Subject: FW: FAO Lucy Walker

Subject: FAO Lucy Walker

3/2024/0029

5 The Dene, Hurst Green, Clitheroe, BB7 9QF Proposed Elevations

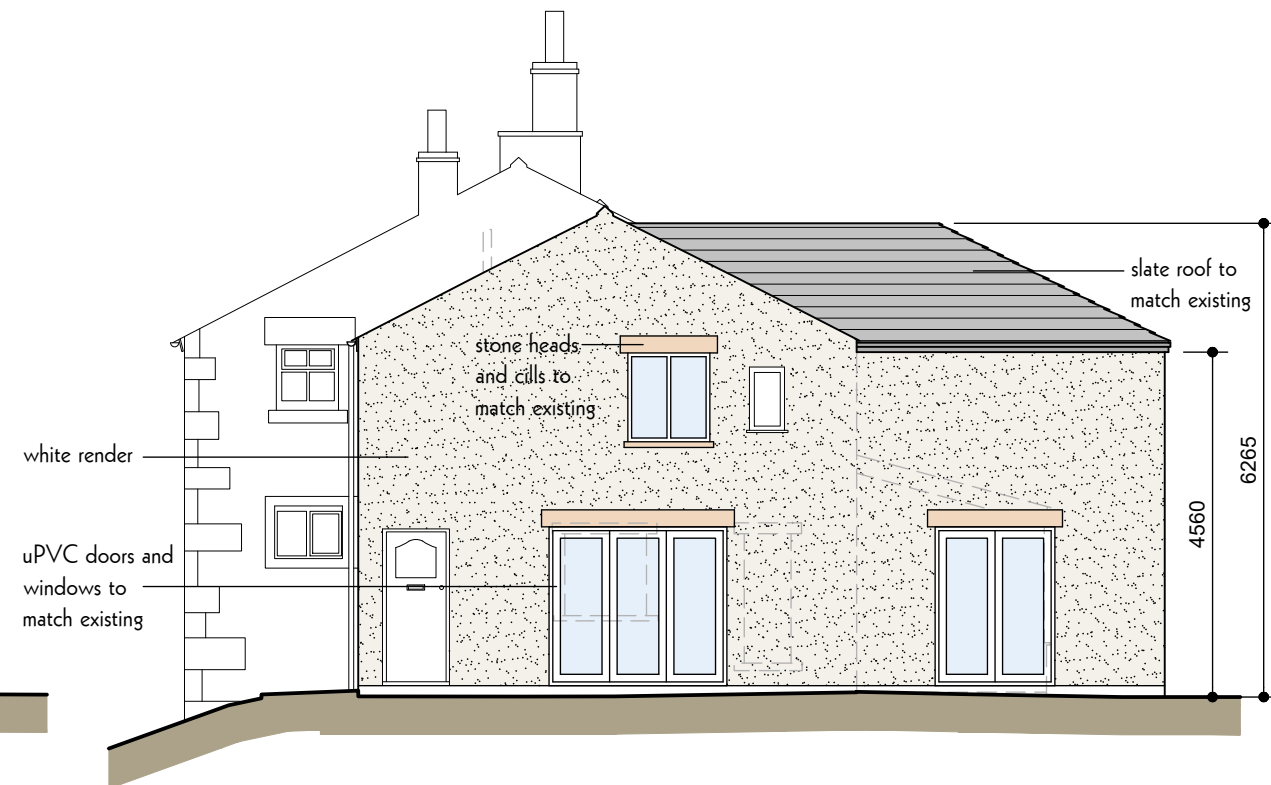
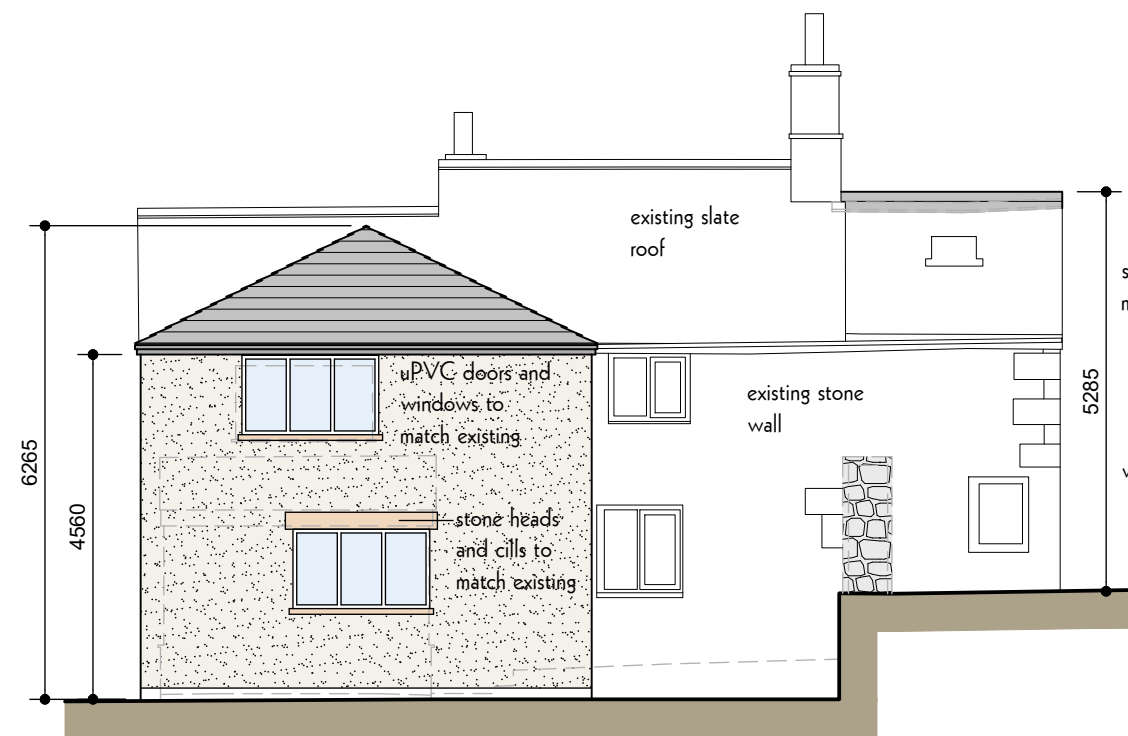
I just reviewed the plans that were resubmitted, however, they are still incorrect, I have outlined 2 windows that no longer exist and have either been removed or are now below ground level.

Proposed Site Layout

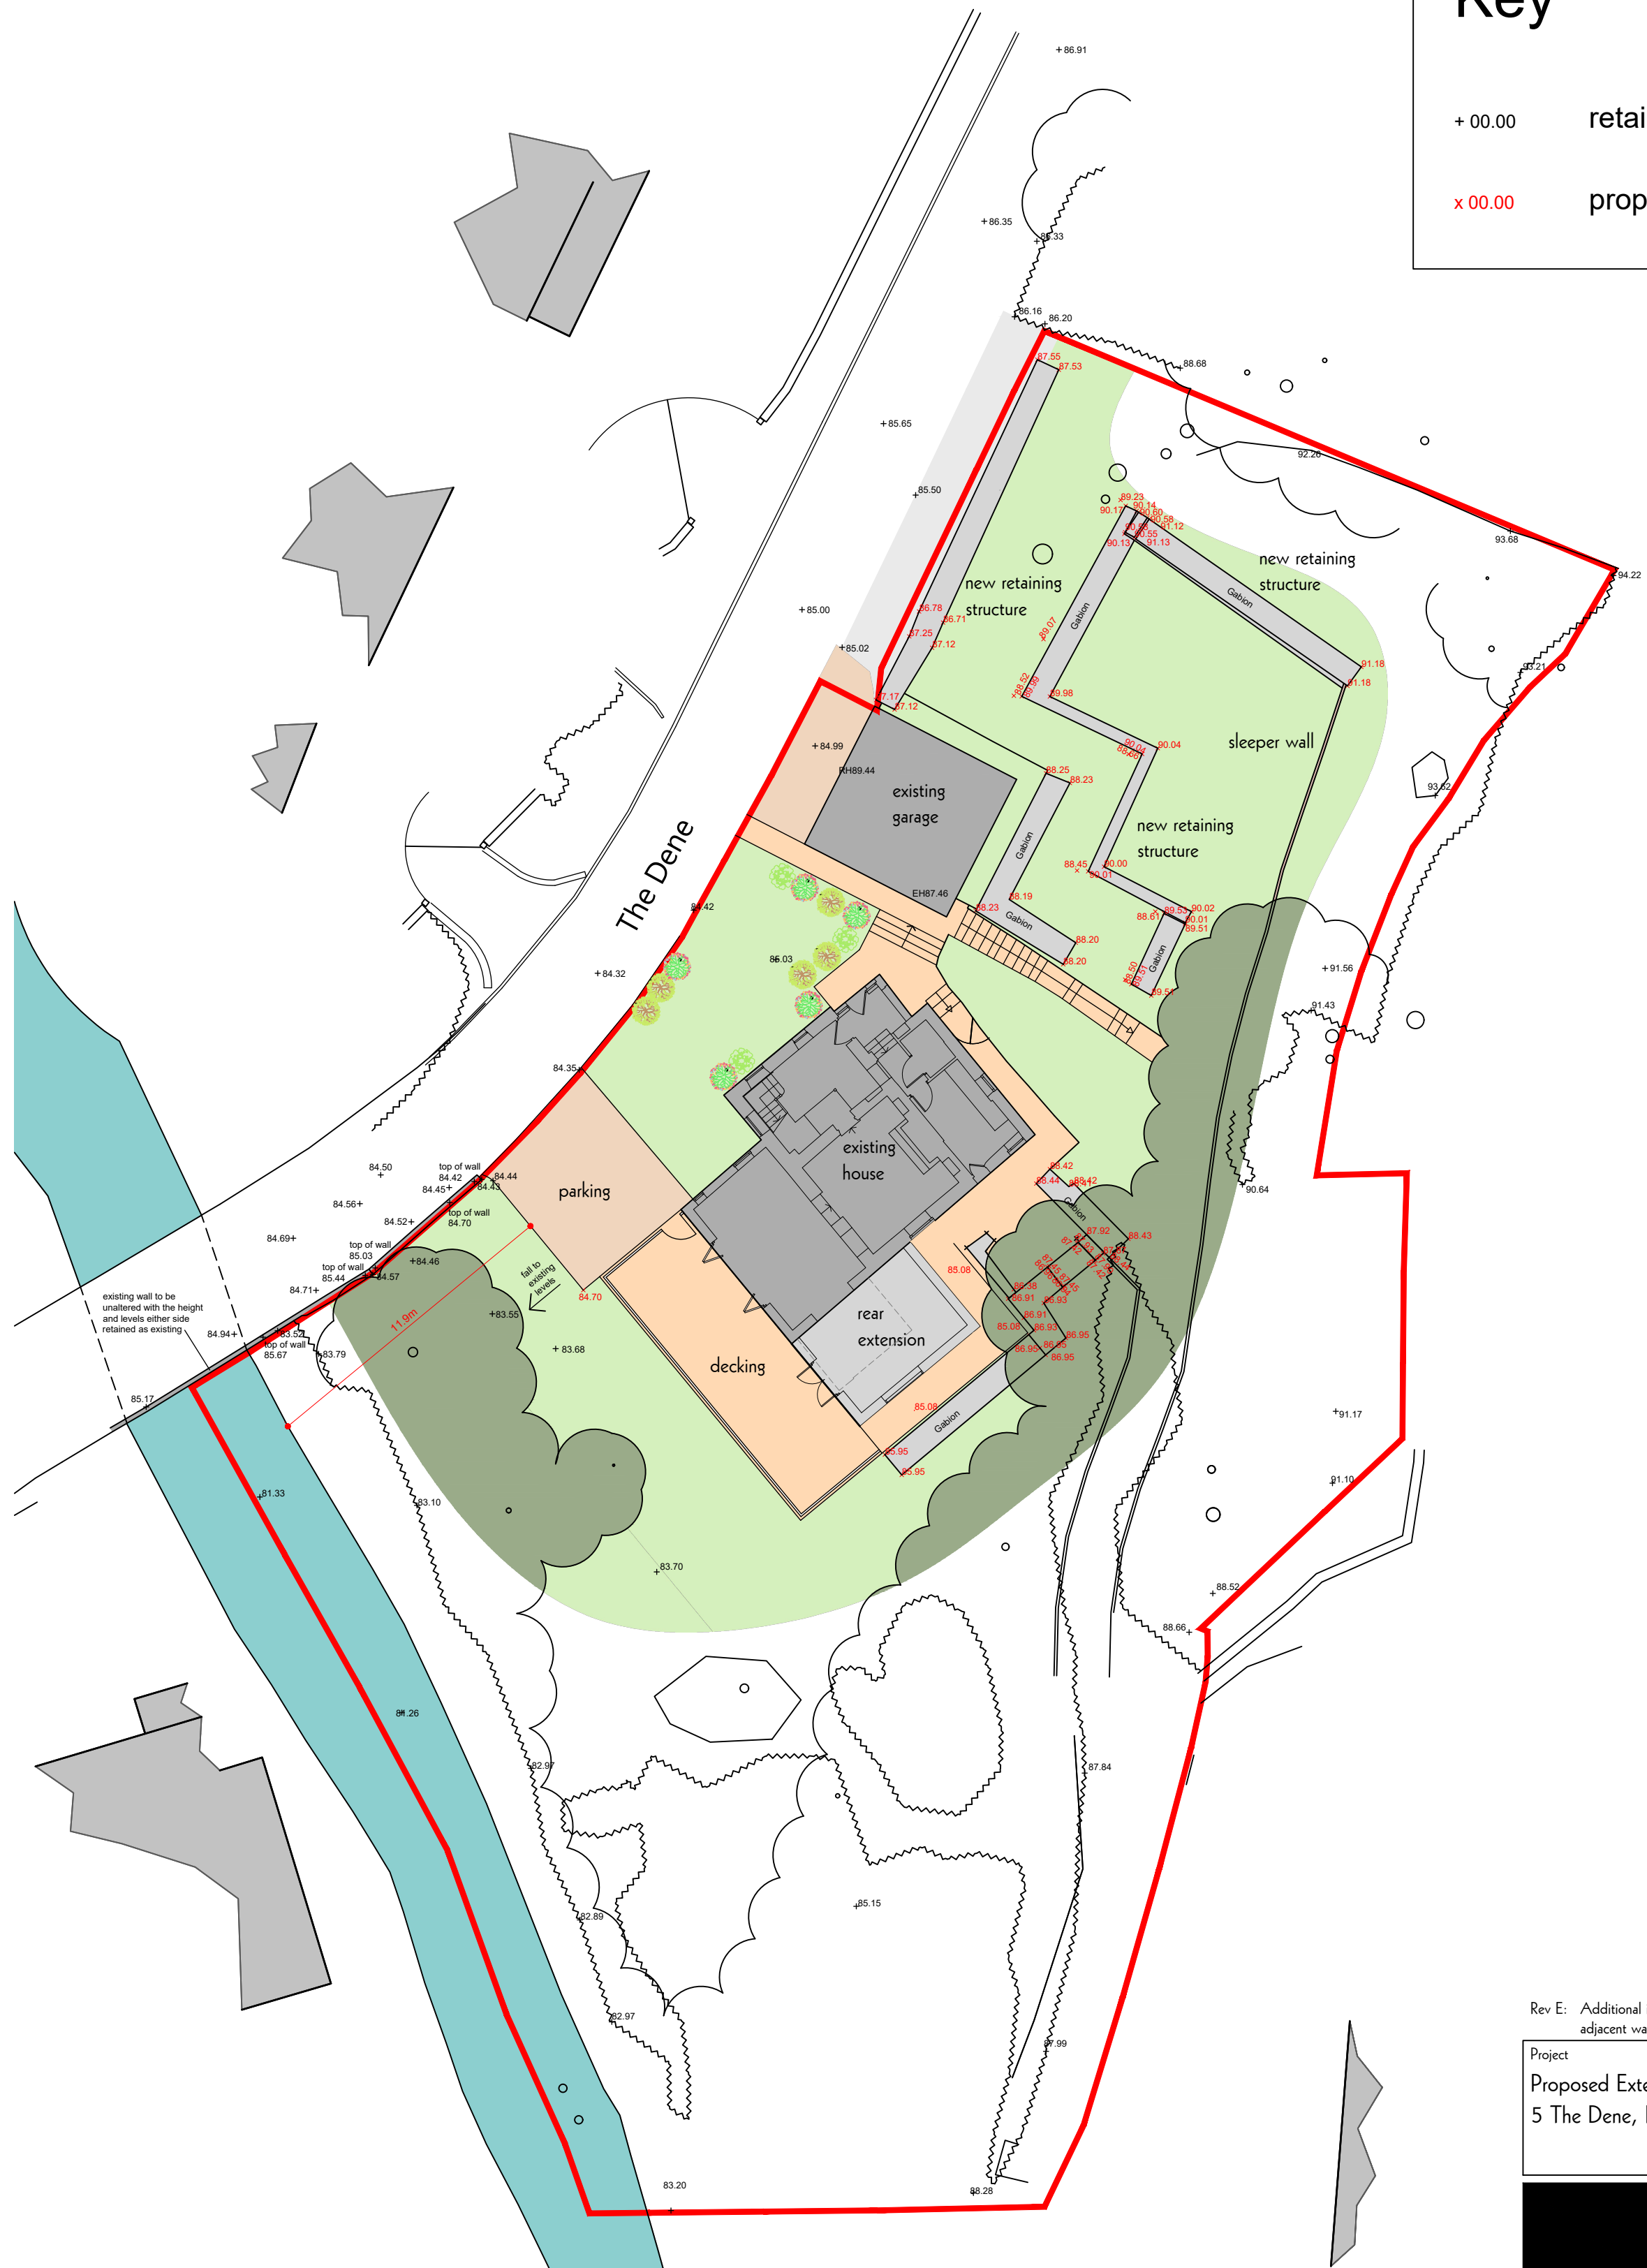
It also seems that the developer has not submitted any plans with original ground levels prior to commencing work on the property, it is clear to see that the land between the property and the river continues to be raised even to this day. I am sorry to sound like a broken record, however, how can plans be submitted for planning purposes that do not show accurate pre and post ground levels in an AONB/Conservation Area.
